**Consultation Response from KC,
Trees**

**2024/91760 Land adj Healey Junior Infants and Nursery School, Healey Lane, Healey, Batley,
WF17 8BN**

**Erection of 19 dwellinghouses with associated car parking, landscaping and boundary
treatment and other associated works**

Date Responded: 03/12/2024

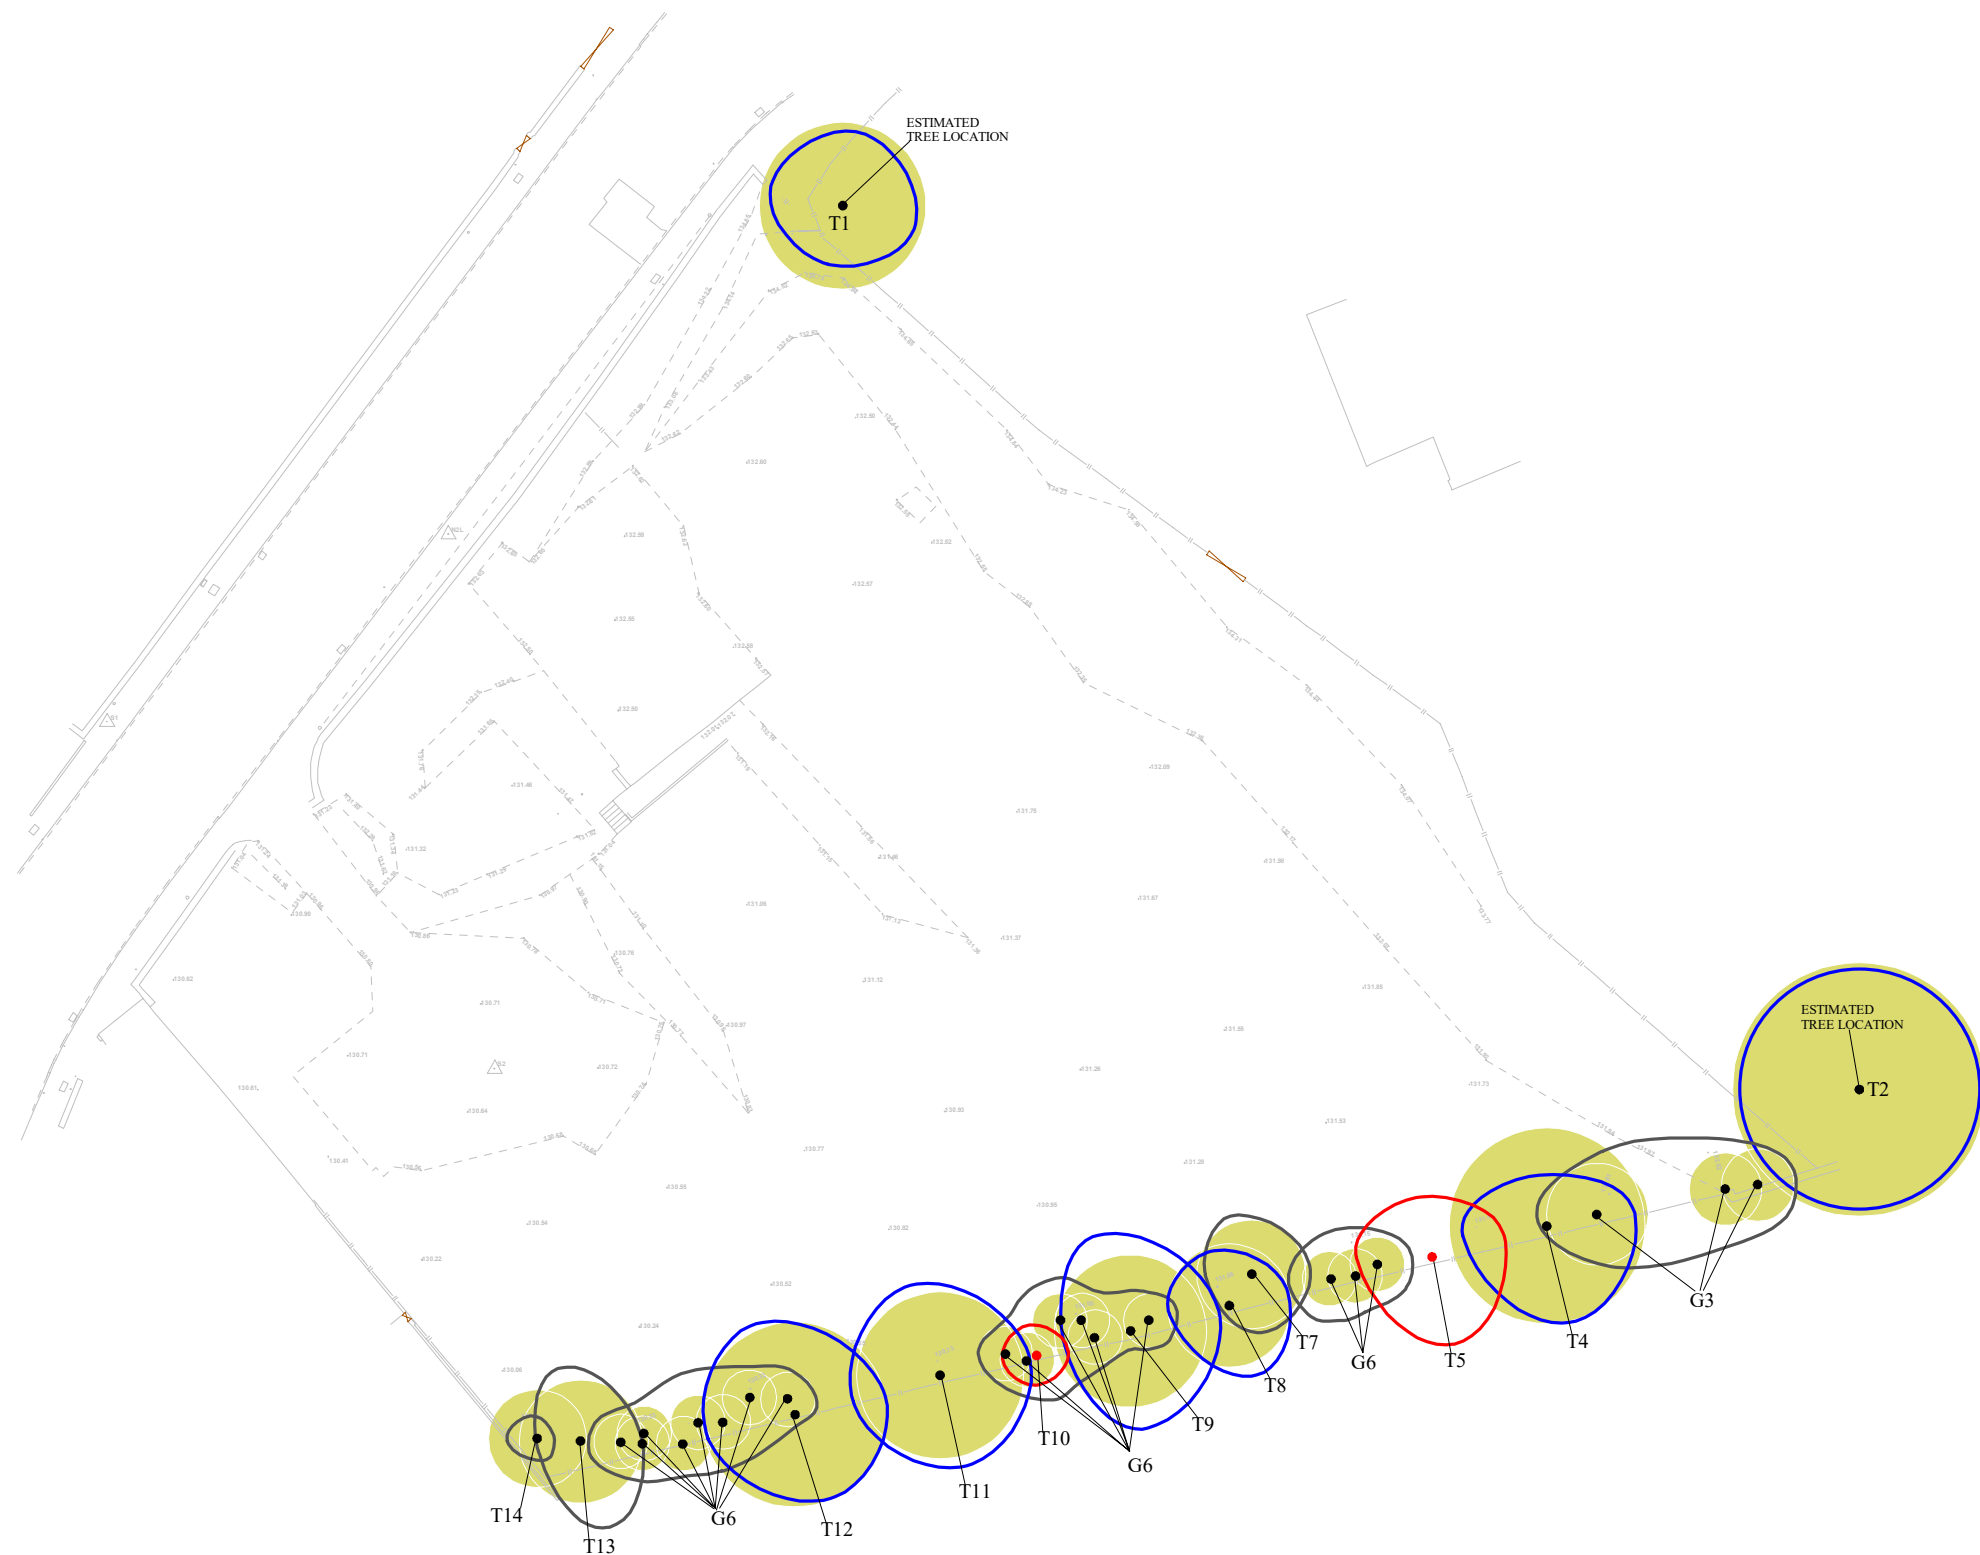
The only impact on any trees appears to be within the Root protection area of T1. This infringement is minimal and should not result in any future problems for the tree.

The submitted Arboricultural Method Statement sufficiently details that there will be no impacts on any of the other trees on site and that the tree protection measures will be in place to keep all construction outside of RPA's.
